Frodsham Solar

Statement of Common Ground with the Environment Agency

PINS Ref: EN010153

Document Ref: EN010153/DR/8.17

**CROSSING CP22 PROPOSED SECTION B-B
ALTERNATE ARRANGEMENT
1:50**

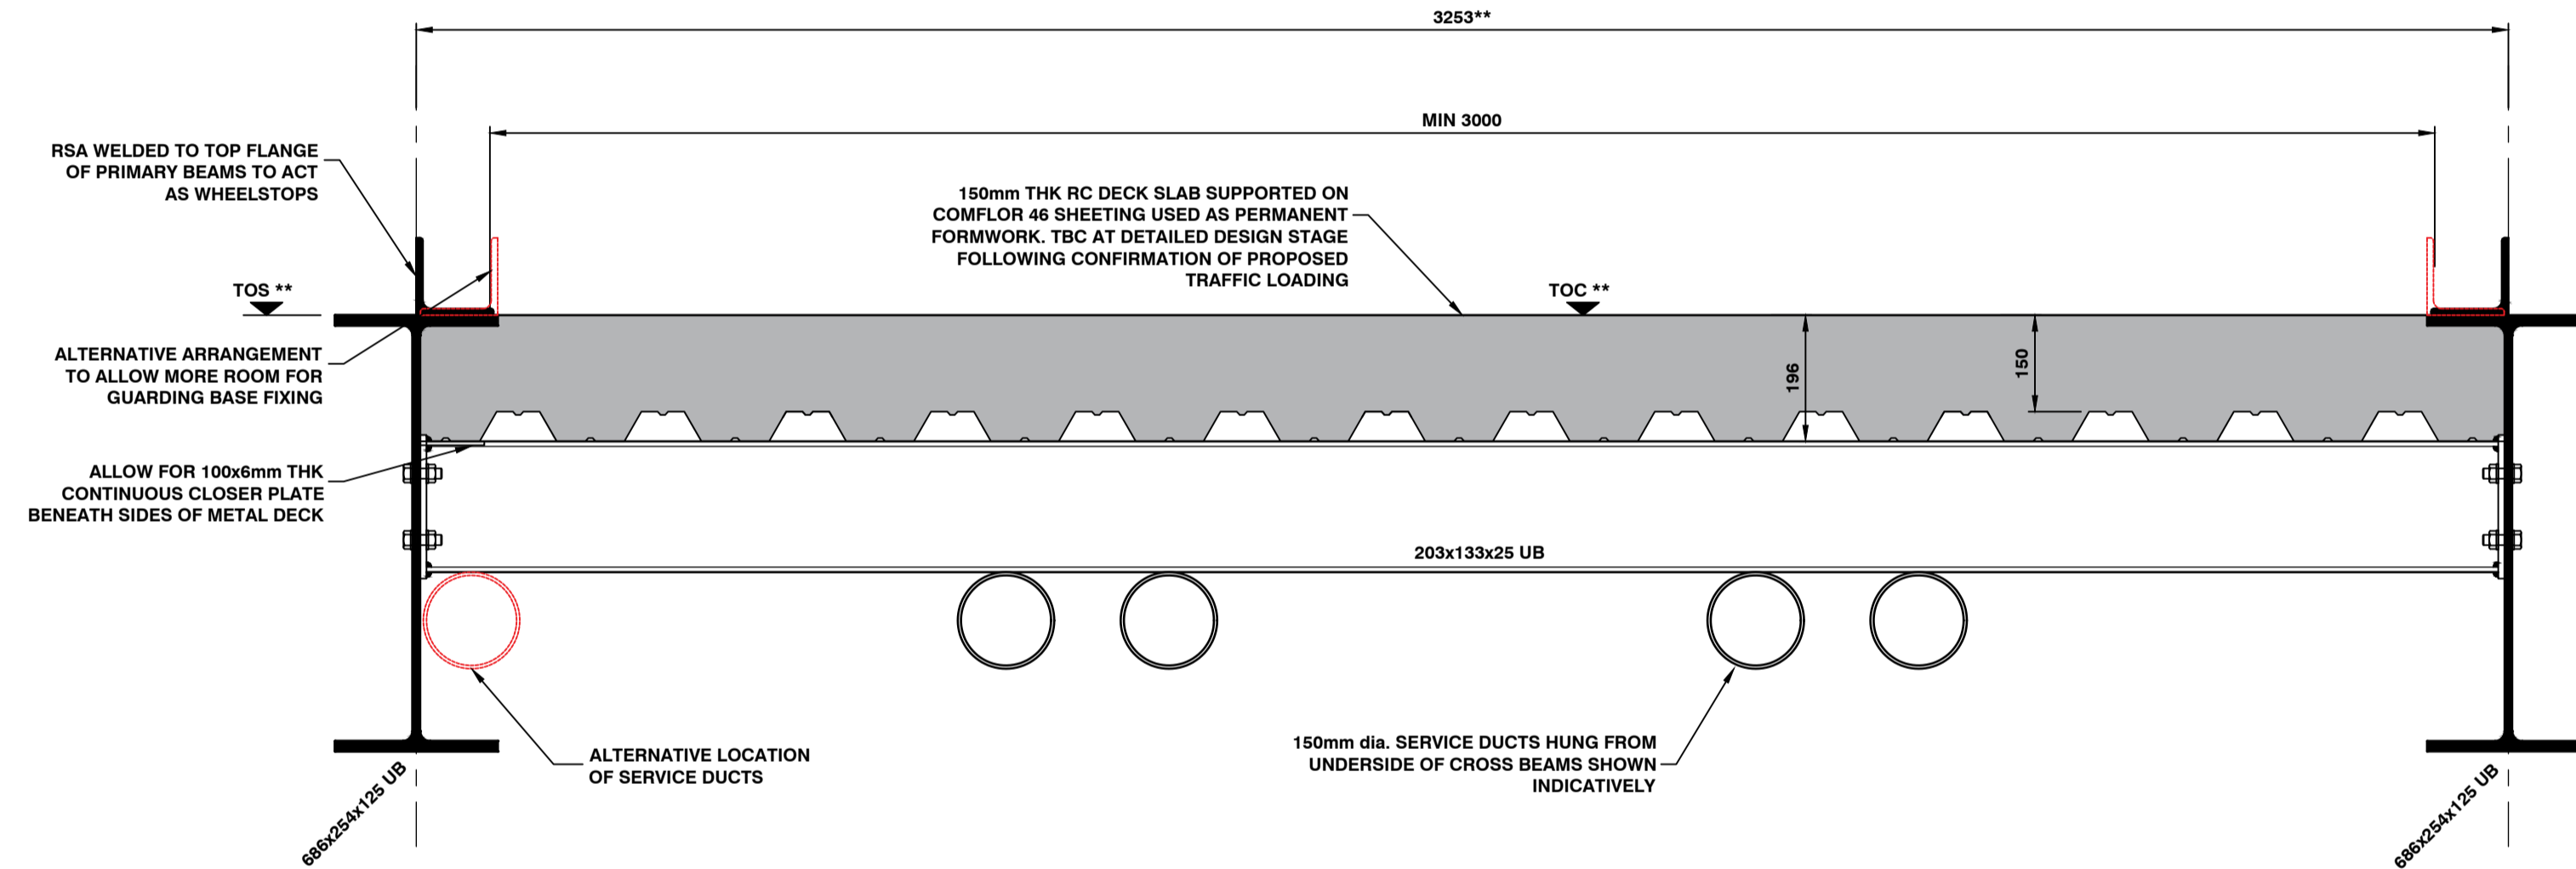
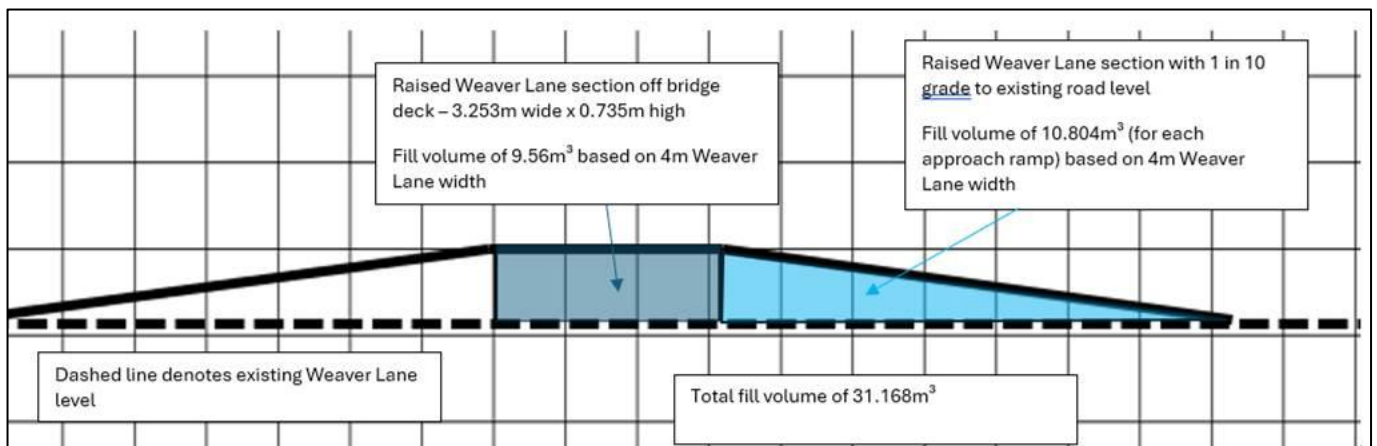
Marh – April 2026	Email	The Applicant has exchanged emails with the EA in relation to remaining matters requiring in agreement, in particular in relation to FRAP disapplication and the design of CP22.

Ref.	Matter	EA Position	Applicant Position	Status
012	<p>The Applicant's approach to designing watercourse crossings.</p> <p><i>EA Issue ID: EA007</i></p>	<p>The EA has concerns about the position of bridge abutments and soffit levels, and that these will reduce conveyance of water during high flow conditions, preclude access to, and threaten the stability of the riverbanks.</p> <p>The EA request that a soffit level at least 0.6metres is provided from the bank top, as set out in the Standard rules SR2015 No 28 guidance. The EA require a 2m offset for the abutments to ensure that geomorphological processes aren't impacted.</p> <p>The EA has requested that the Applicant provides a 600mm freeboard between the bridge soffit and top bank level for CP14 and CP17, and a 300mm freeboard at CP21.</p>	<p>The Applicant has provided drawings for CP14, CP17 and CP21 demonstrating that the required freeboard can be provided.</p>	Matter Agreed.
